**PLANNING ACT 2008 – SECTION 88 AND THE INFRASTRUCTURE
PLANNING (EXAMINATION PROCEDURE) RULES 2010: APPLICATION BY
HIGHWAYS ENGLAND FOR AN ORDER GRANTING DEVELOPMENT
CONSENT FOR THE A1 BIRTLEY TO COAL HOUSE IMPROVEMENT
SCHEME (DEADLINE 1: WRITTEN REPRESENTATIONS)**

A1 Birtley to Coal House Improvement Scheme DCO Application Planning Inspectorate Reference: TR010031

Summary of Written Representations On behalf of the Environment Agency (EA)

Drawing Title COMPOSITE LAND AND WORKS PLANS
SHEET 2 OF 5
REGULATION 5(2)(i)

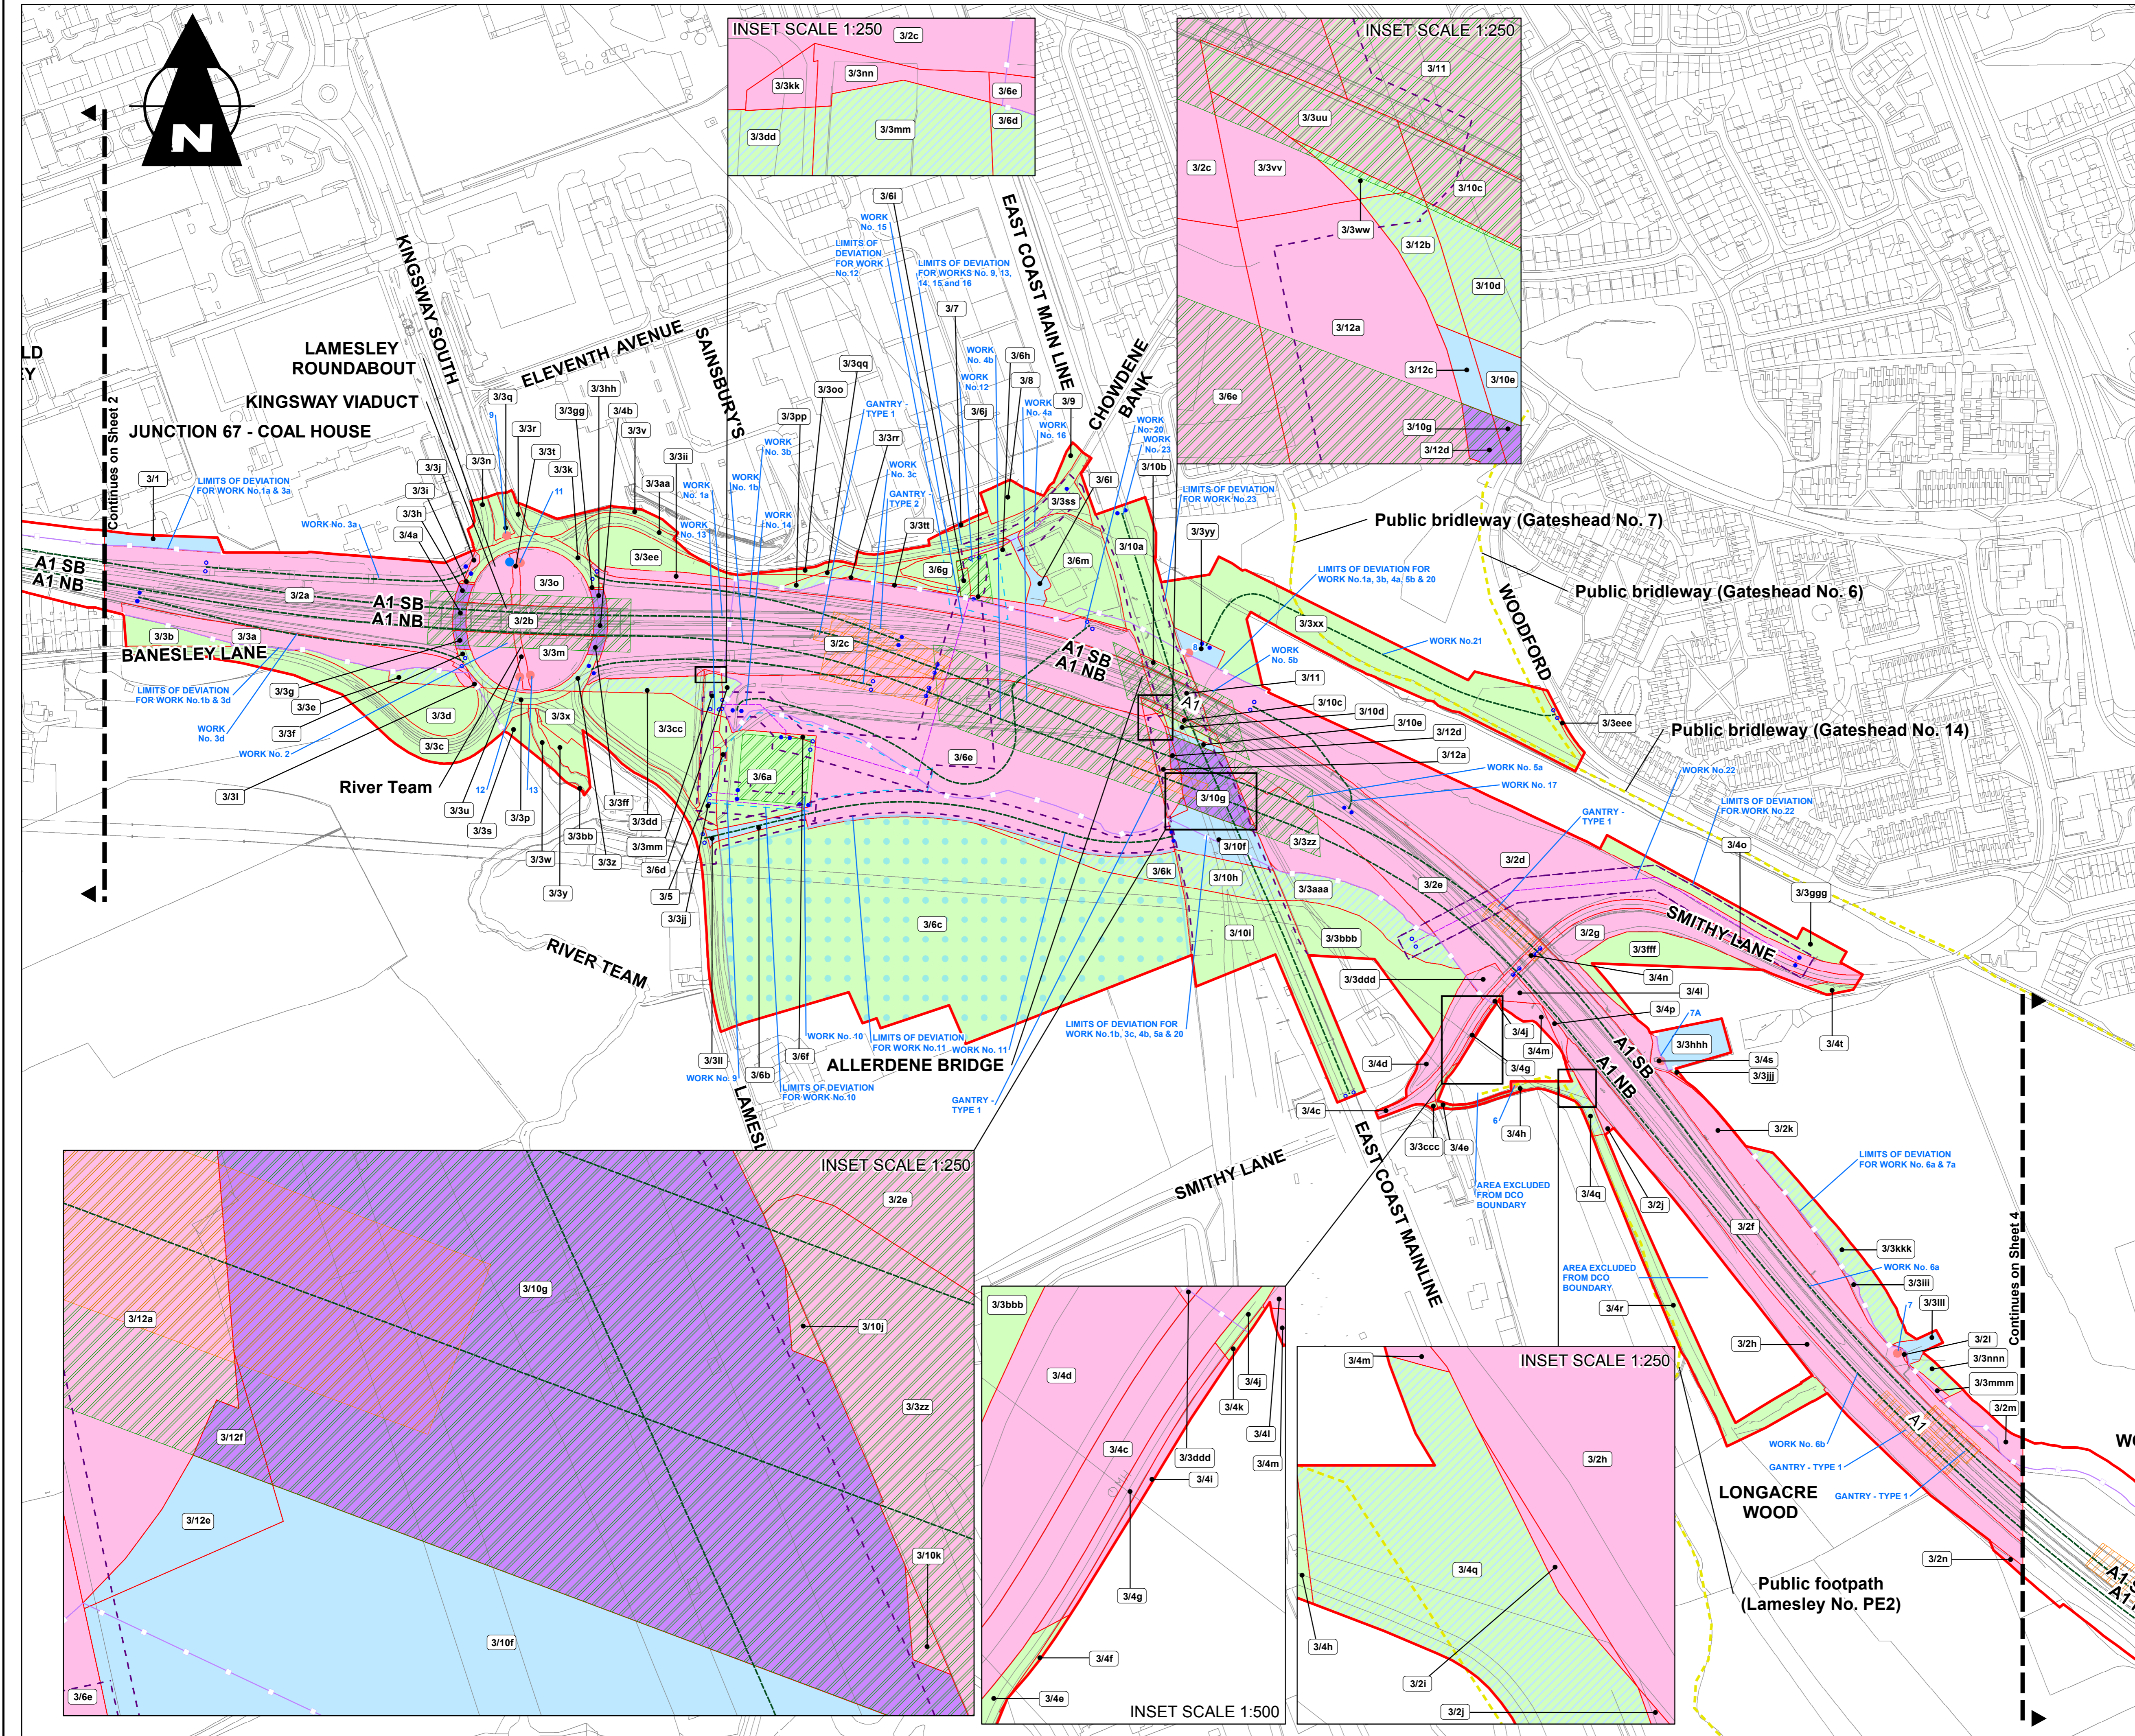
Drawing title ‘land Plan sheet 3 of 5 Regulation 5(2)(i) HE551462 /WSP/LS1’ dated 24/7/2019 (located within document 2.2. Land Plan) illustrates the temporary possession, and the permanent acquisition of rights over land. Areas 3/3x and 3/3y show the temporary possession of land. This is also the location of our gauging station and telemetry software. It appears sections 3/3x and 3/3y will be used temporarily during the construction of the road scheme. However no details have been provided by the applicant regarding what this land will be used for, the types of works to be undertaken and the timescales for any works. This information must be submitted as part of the DCO application. As this is an essential piece of infrastructure, we will not **allow any works or temporary possession of this land as it may affect our ability to undertake our statutory duties and powers.**

There are limited flood risk impacts associated with the proposed bridge pillar extension and the proposed mitigation next to the River Team. However, the applicant has failed provide any assessment or information regarding the potential impact the proposed works will have on our flood risk gauging station and telemetry software, and how the rating curve may need to be changed due to the increase in channel levels for certain return periods i.e. how the development will affect the accuracy and the performance of the telemetry to read the river levels. This information is fundamental to the development of hydraulic models and the issuing of flood alerts and warnings.

The information submitted to date by the applicant does not provide us with any detail to reassure us there will be no impact on our gauging station and telemetry software. This information must be submitted as part of the DCO application. It should be noted that we would expect the applicant to fund the work our Hydrology team will need to do to recalibrate the gauge. We would welcome further discussions with the applicant regarding this issue or the inclusion a requirement within the DCO regarding this matter.
